March 10, 2020

Pre-Application RESPONSE for a new Building Permit

This is an application for a new building permit to replace permit 1306-055, which expired in October 2019 without notification. The slope of this lot is 19.36%, which allows a 35% lot coverage. This project is a new single family residence of 4,840 s.f. finished area, with an attached garage of 841 s.f. There is also 470 s.f. of open decking, with a GFA of 37.44% < 40%. The project has a gross lot area of 14,203 s.f., which includes an access easement of 2,203 s.f., yielding a net lot area of 12,000 s.f., but only 758 s.f. of this easement is used for access to this lot. There is also 662 s.f. of allowable hardscape surfaces, which is 6.13%, and this is less than the allowable of 1,080 s.f. (9%). The existing building permit 1306-055 was under the previous City Code and included a 5% impervious surfaces deviation, for a total of 40% impervious surfaces.

DRAWING NO:  
**C2.1**  
APN 5315100056  
AND 5315100055

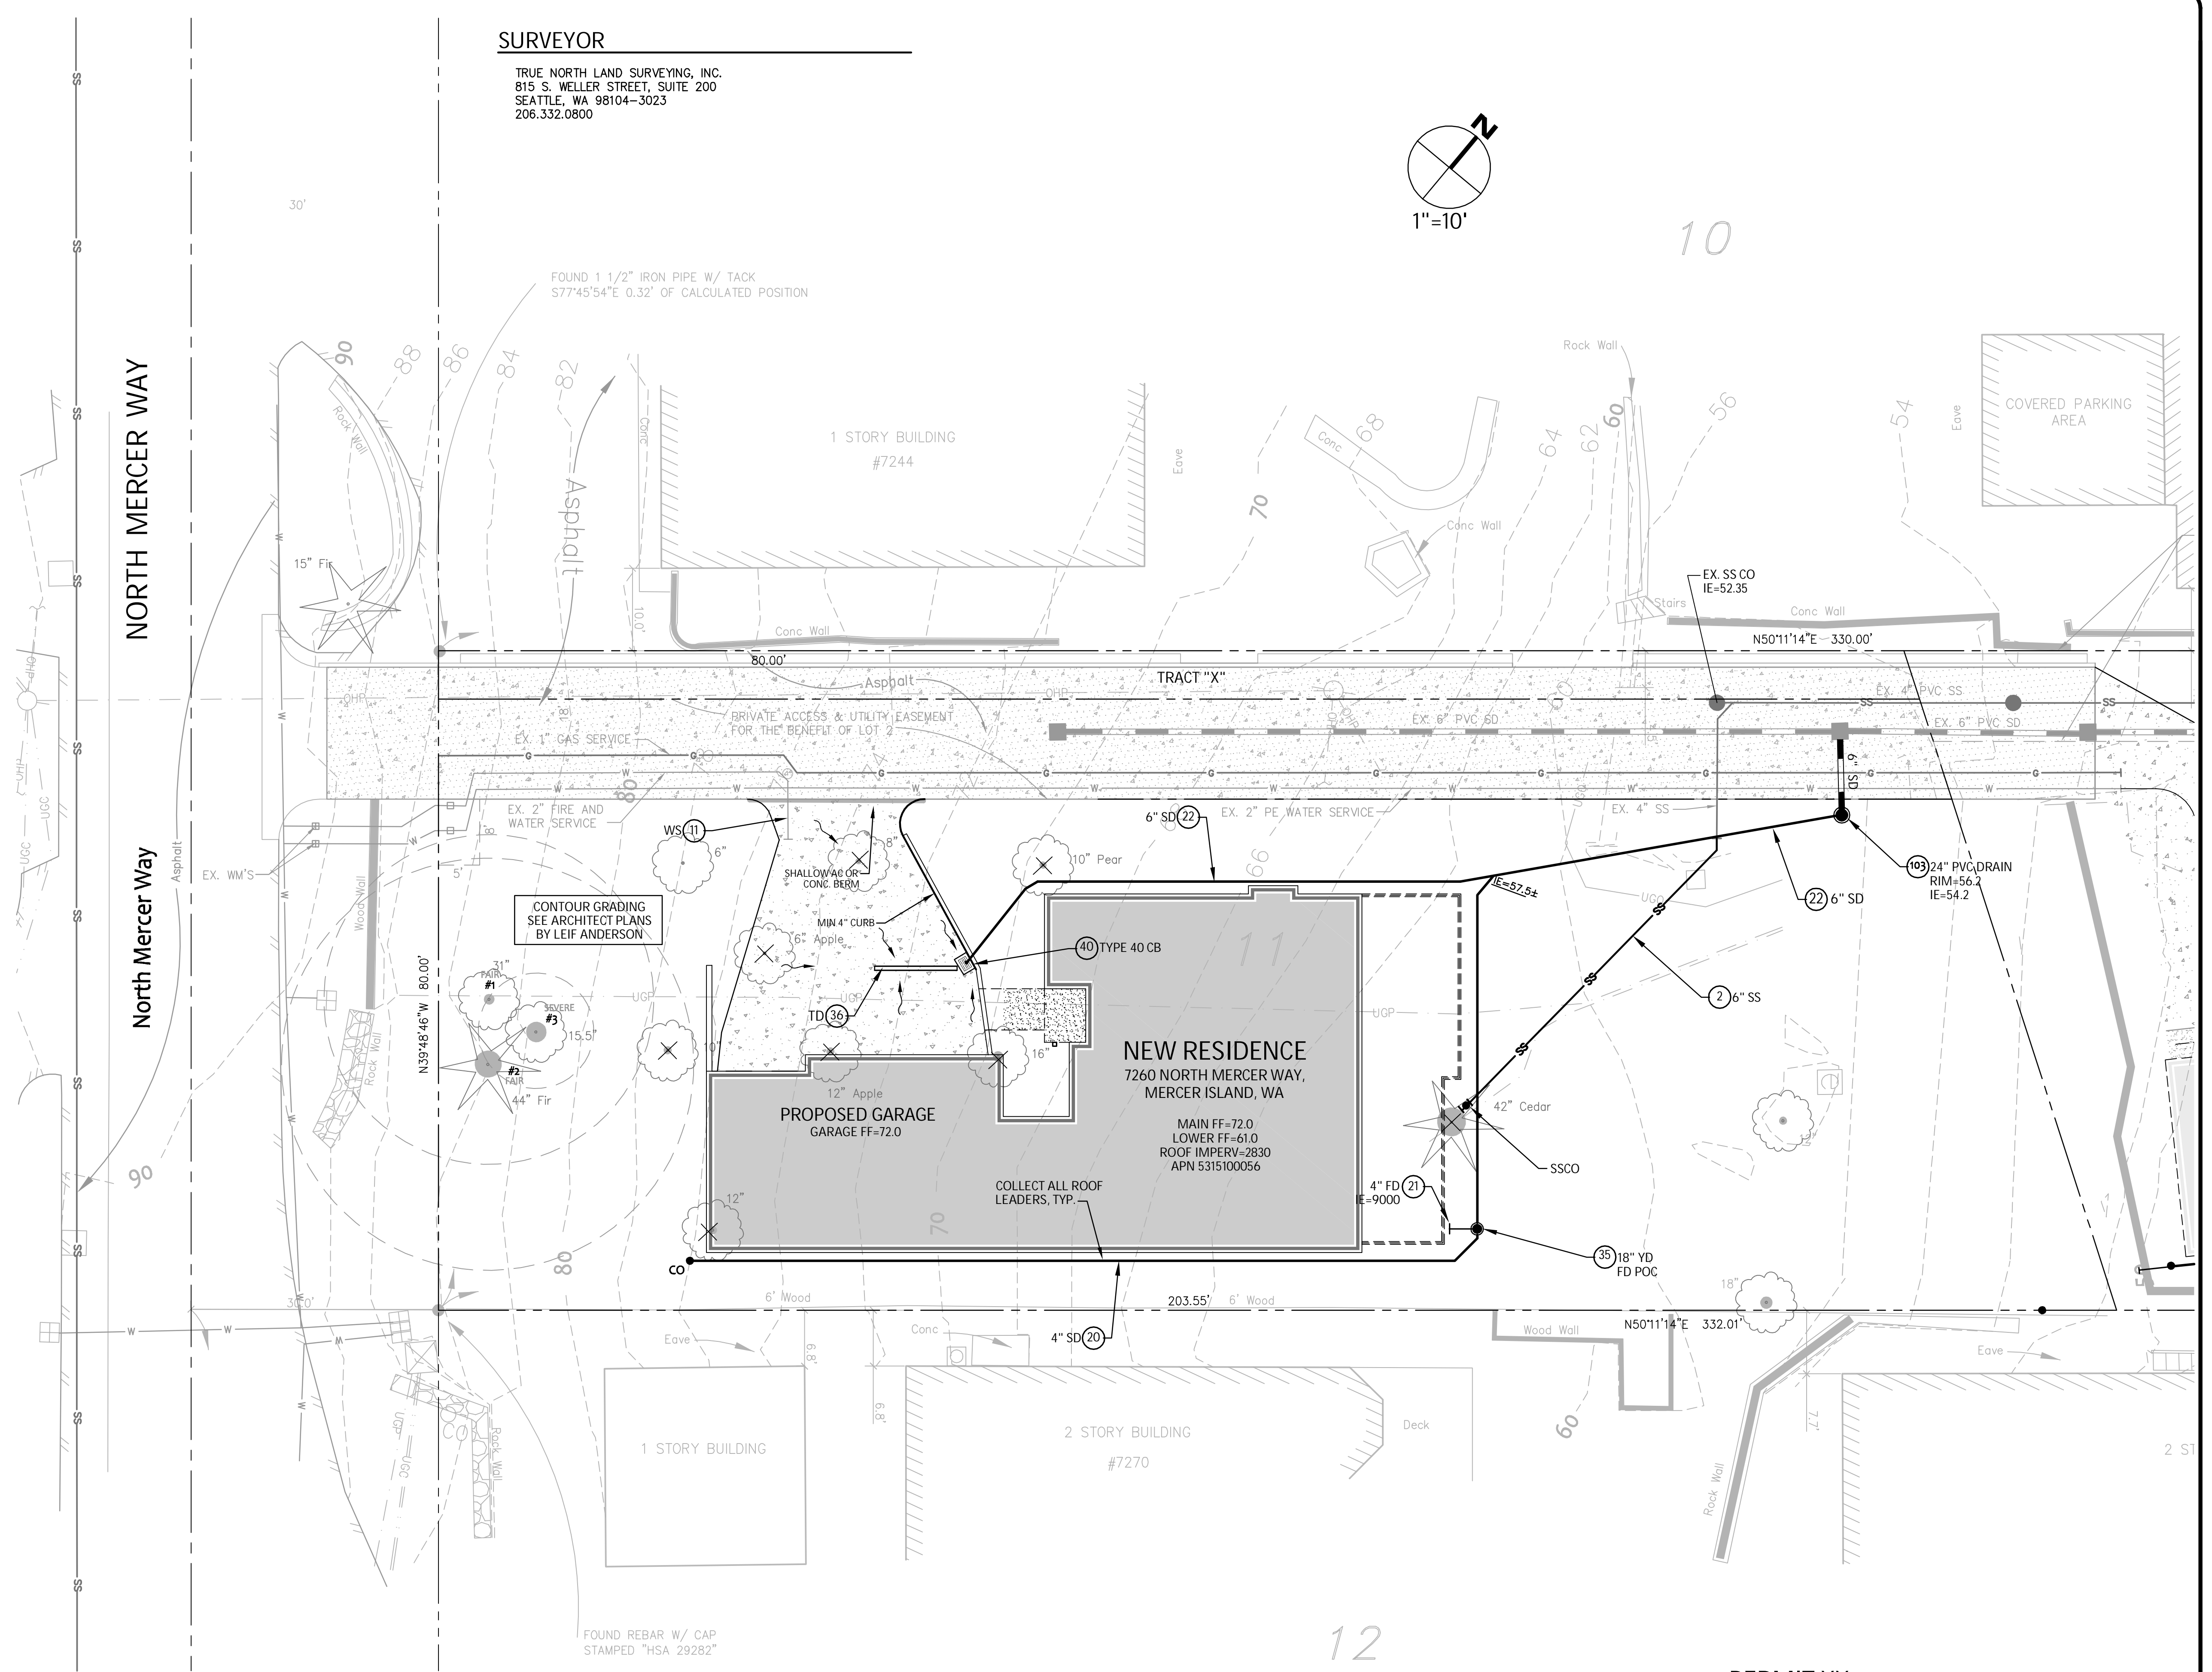
1. Noted.
2. a. The requested note has been added to the drainage plan.
b. An updated drainage report is being provided.
c. Noted.

Drawing file: SUB1 / site_plan_sht.1_revised_6-6-20.pdf

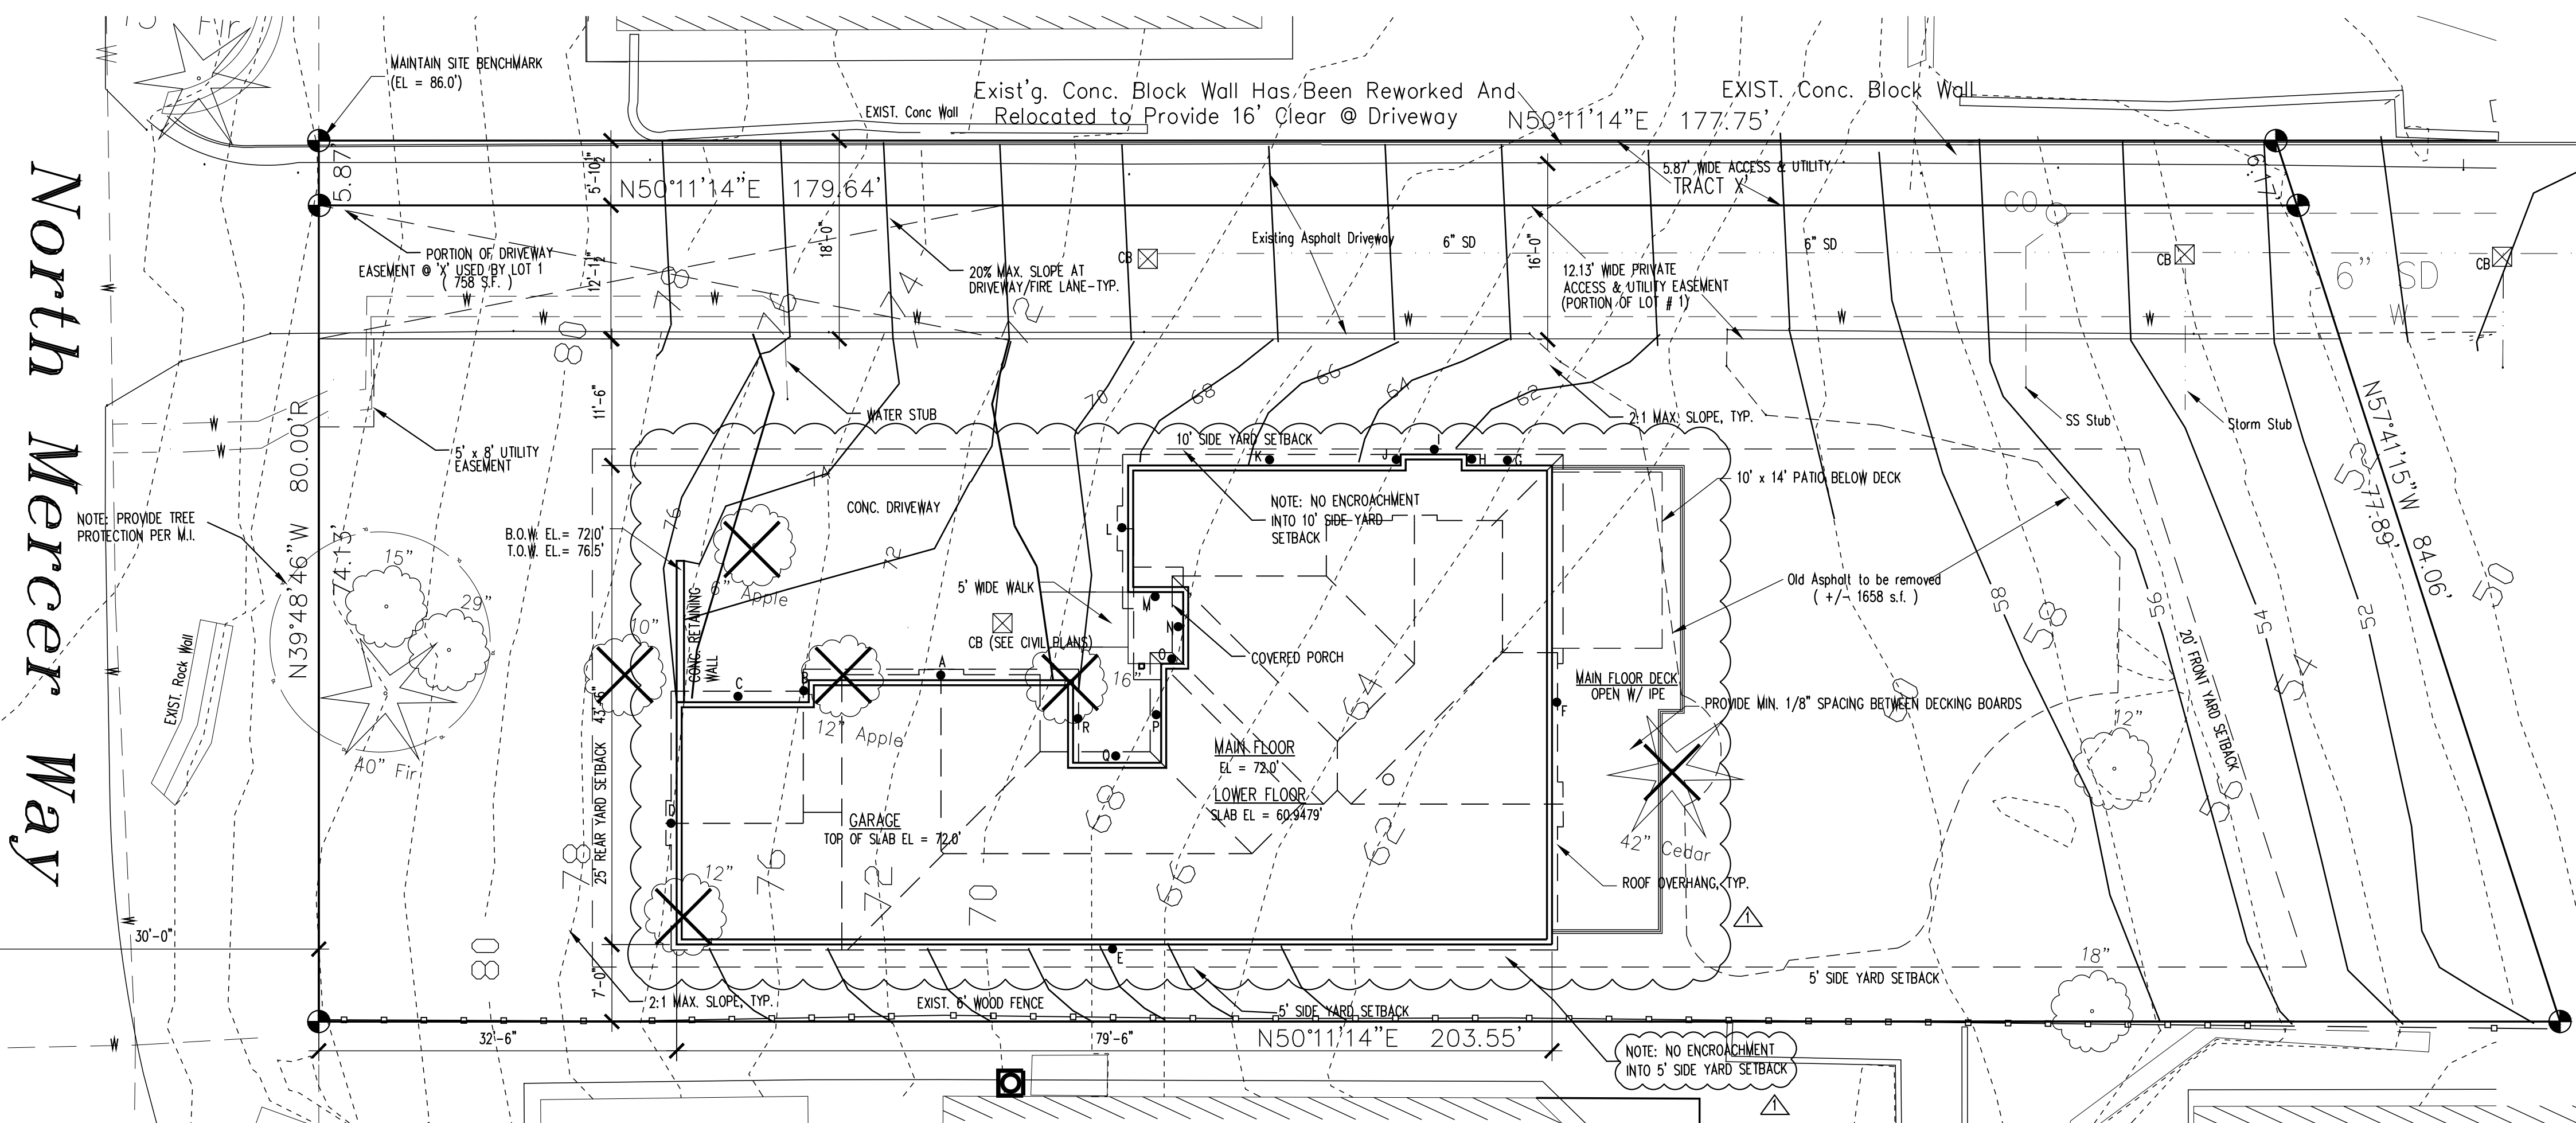
3. The southern side yard setback will remain as is per MICC 19.01.050(D)(1)(b)(i). There will be NO structural alterations along the length of the exterior; the original 15' long by 1'-6" deep cantilevered area of the 2nd floor was removed from the site plan, because it was never constructed.
